Application No: EP/69/21/PL
Site Address: 4 Beechlands Close and east of 18 Beechlands Court Montpelier Road East Preston BN16 1JZ
Description of works: 1 No. 3-bed bungalow (resubmission following EP/10/21/PL). This site is in CIL Zone 4 & is CIL Liable as new dwelling.

Thank you for your internet representation made on 25th July 2021 which has been recorded as an objection with the comments as follows:

SITE PLAN

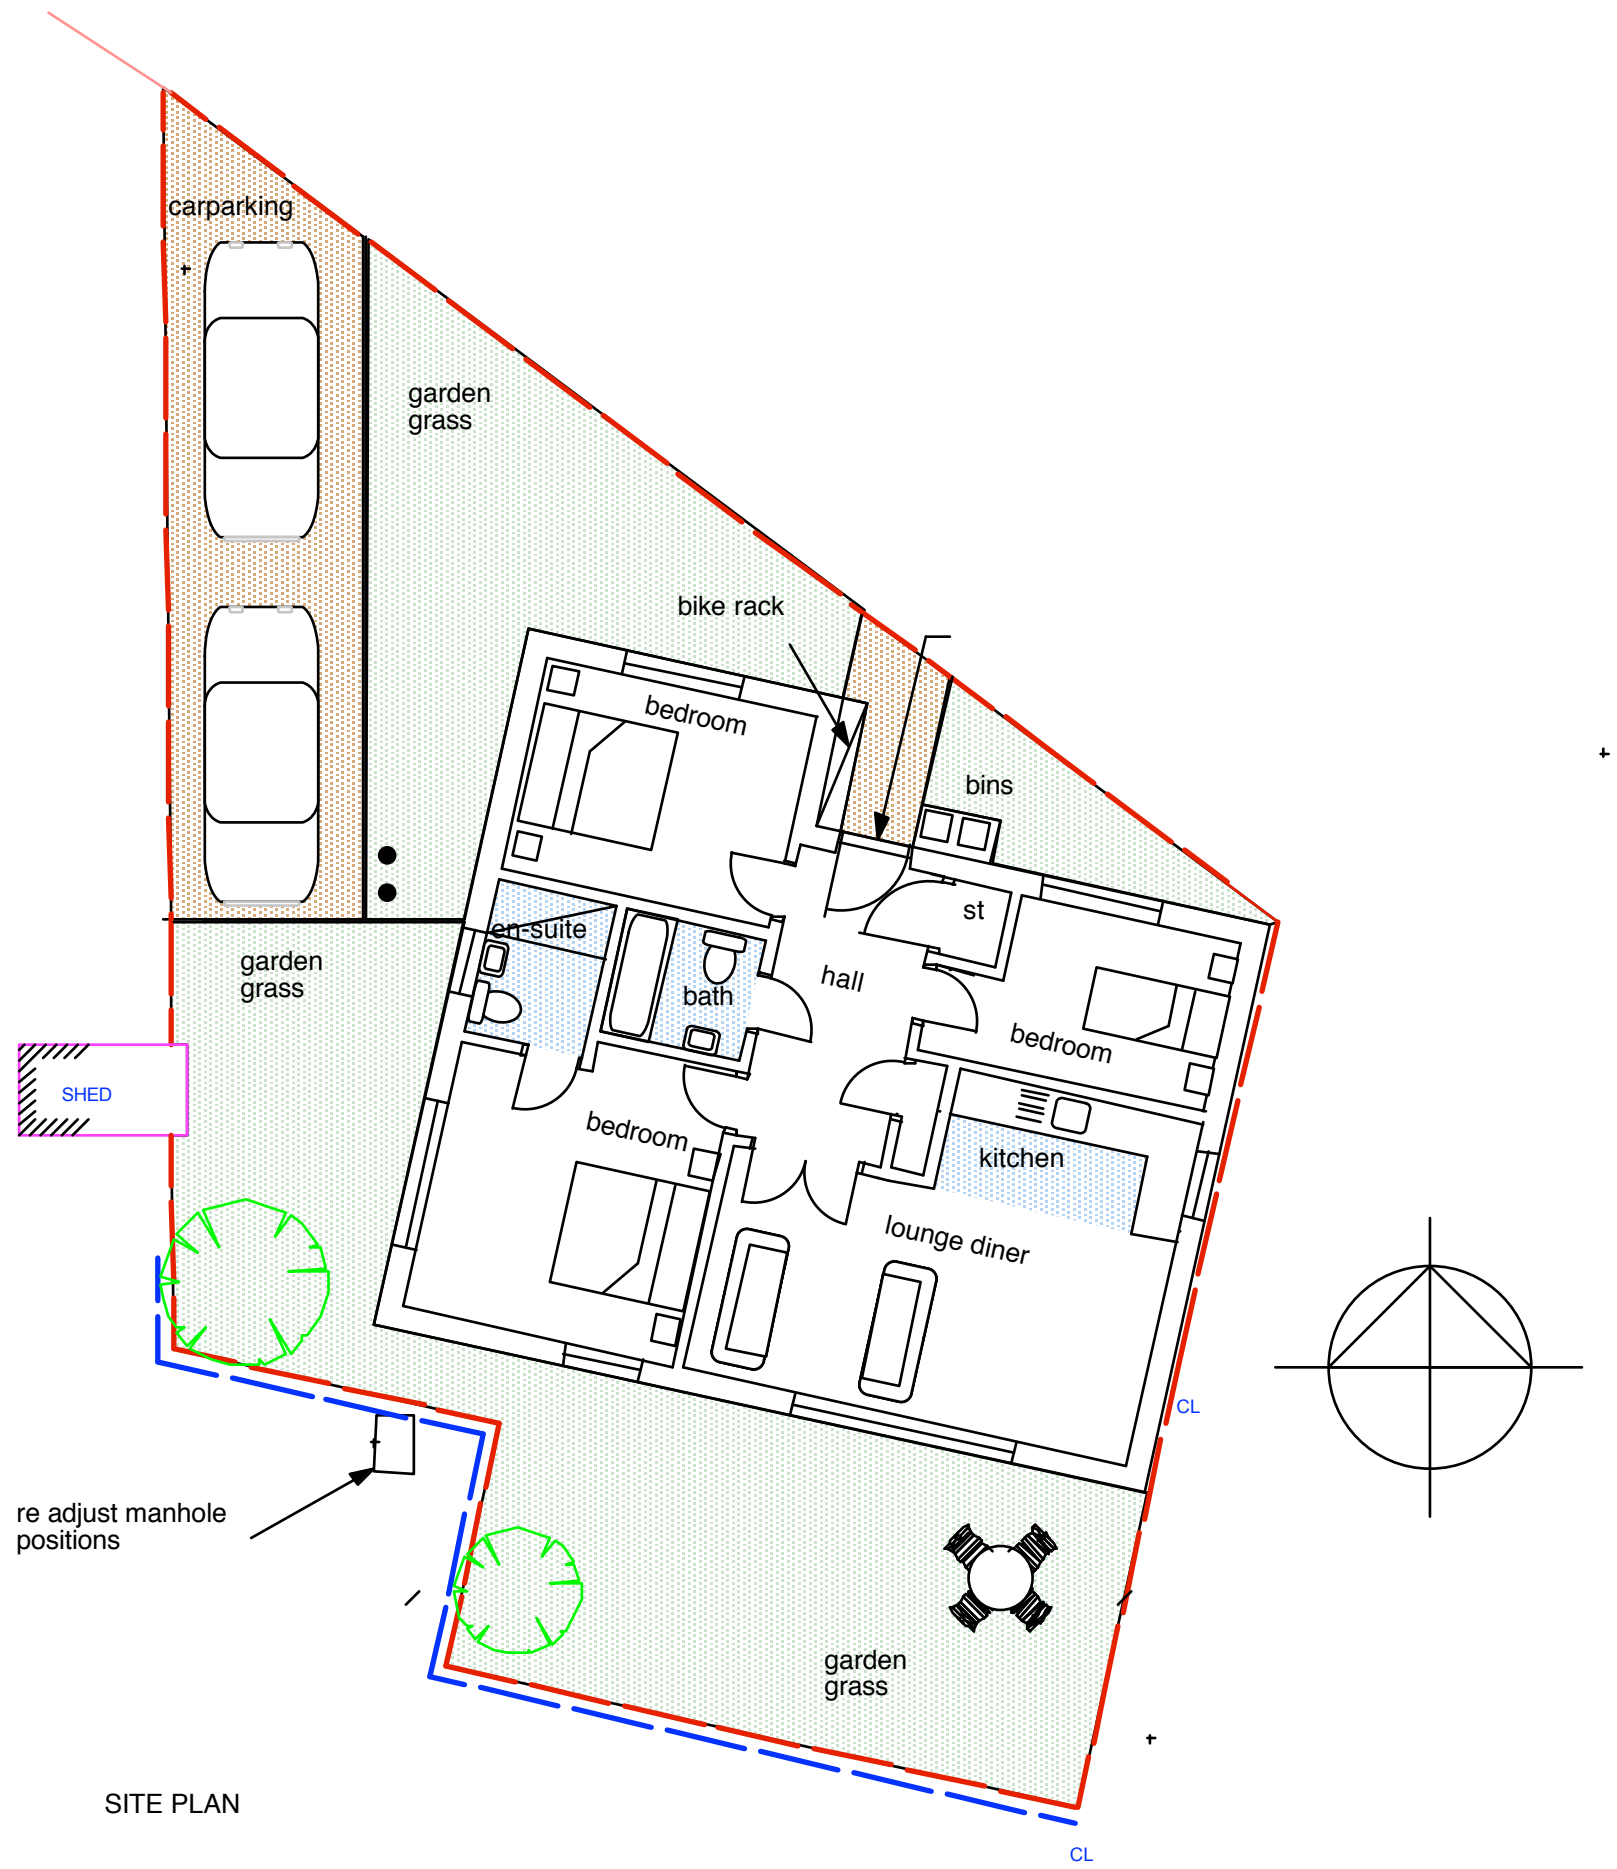
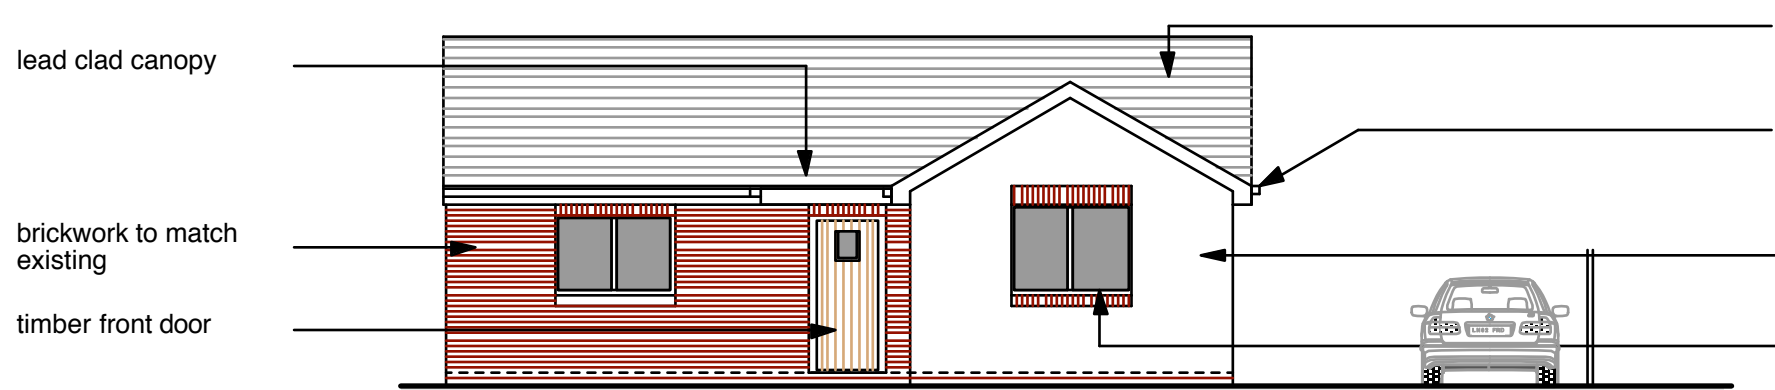
As a resident of Beechlands Ct I know that there is not enough space for this development. There is not enough outside amenity space and on the plan it shows dense shrubs to the east but that is just shrubbery that has been allowed to grow untended over a public right of way and once that has been trimmed back to its original position the footpath will be right next to the building. The plan shows parking for 2 cars but one would have to move to let the other out so realistically they will just end up trying to park on Montpelier Rd which is already too small to accommodate the number of cars that need to be parked there. The plan is for 2 double bedrooms and 1 single bedroom so if 5 people lived there they could own more than 2 cars and the land which is presently part of 18 Beechlands Ct contains a parking space which would be lost adding another car to the road. Montpelier Rd and adjoining car parks already suffer from frequent flooding due to insufficient drainage and around this plan there is not enough garden space to allow for surface water drainage causing more flooding. If this plan went ahead it would be absolute chaos during the building process. There would be nowhere for site traffic to park and with cars parked all along Montpelier Rd there is not enough space for 2 cars to pass each other, never mind lorries! As it is a cul-de-sac there is nowhere to turn except in the private car parks belonging to the residents of Beechlands Ct. The surface of these car parks is already damaged and the residents are in the process of getting them replaced at great expense to themselves and they will not welcome site traffic trying to turn round in them. There are already too many people living in this small area and adding another 5 will exacerbate the sometimes tense atmosphere that exists around the lack of space and parking problems. Please do not let it go ahead.
